CITY OF ALBUQUERQUE

**RE: Advanced Auto Parts
Grading and Drainage Plan
Engineer's Stamp Date 9-15-2015 (File: H14D041)**

Based upon the information provided in your submittal received 9-15-15, the above referenced plan is approved for Building Permit and SO-19 Permit with the following conditions:

C-101

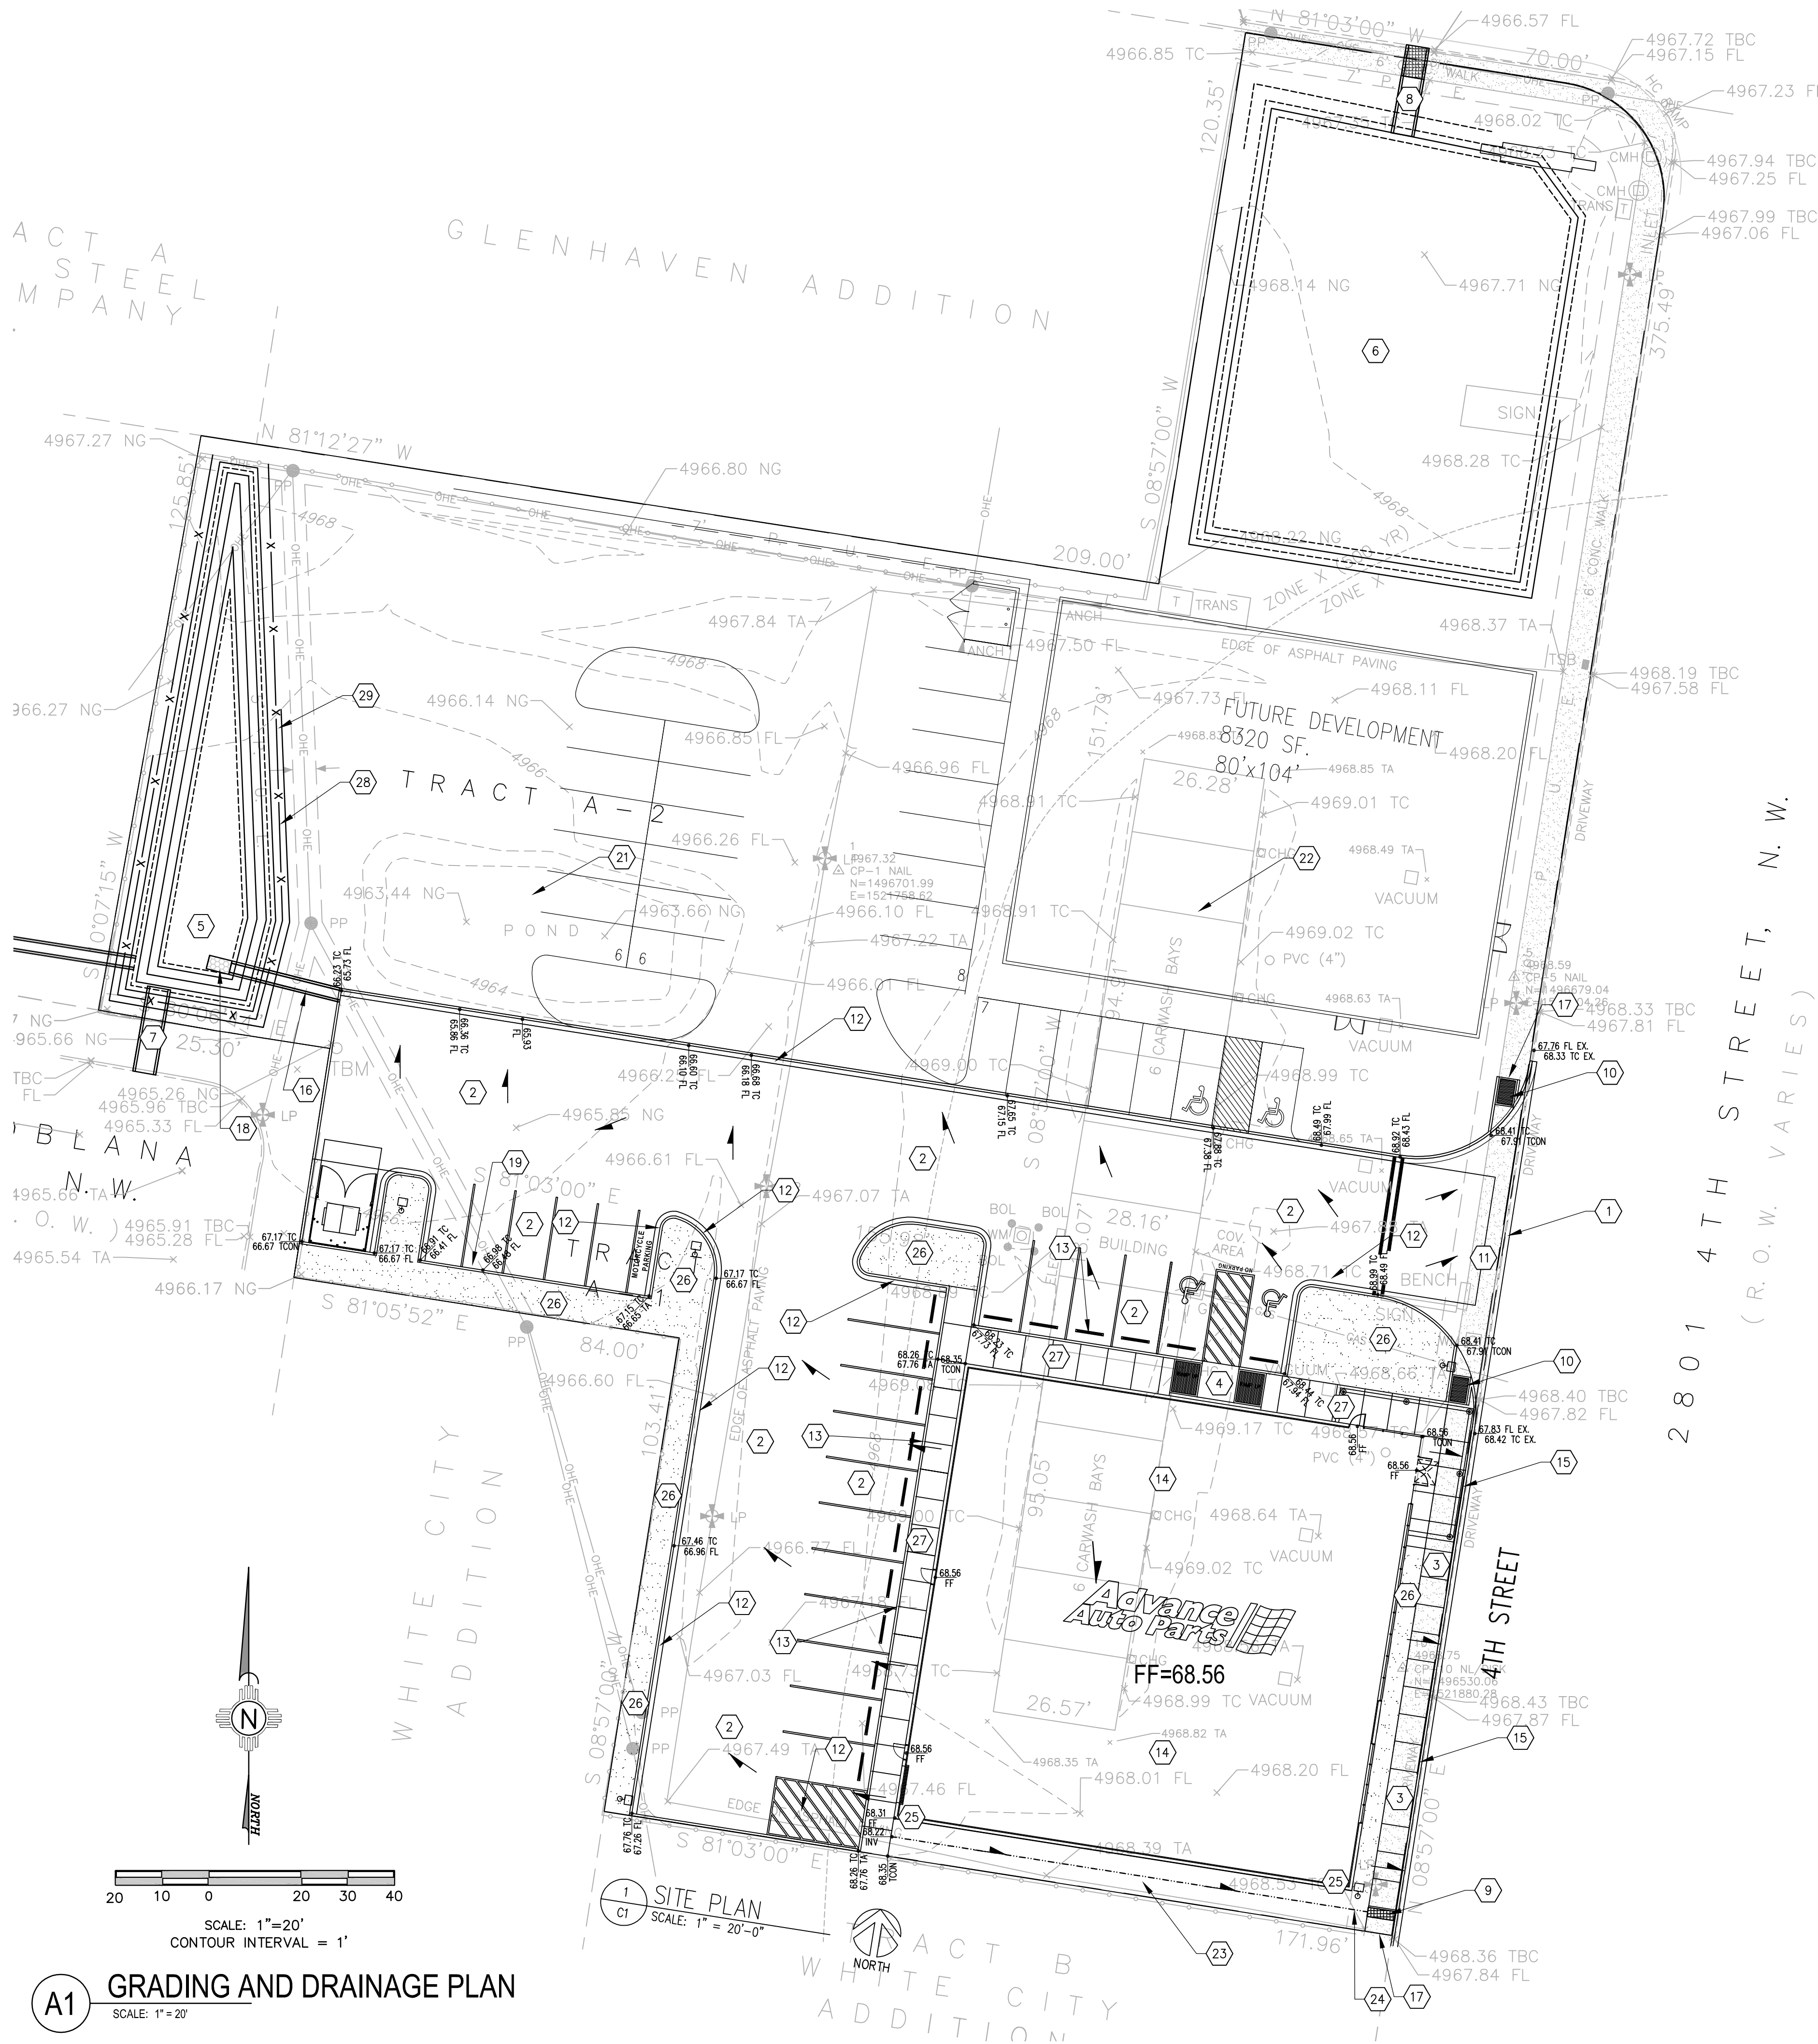
1. Keyed note #9 must be modified to add that the SW culvert (both plate and channel) must be extended 2ft. past the back of Sidewalk. Note that the bolts must be tack welded to the plate.
2. Keyed note #7 must be modified. An open concrete channel presents a tripping hazard. If there is sidewalk, then a Sidewalk culvert should be used (extended per above comment). It is unclear if there is Sidewalk. If there is not sidewalk, then the channel should be an earthen channel filled with riprap to avoid falling into it.
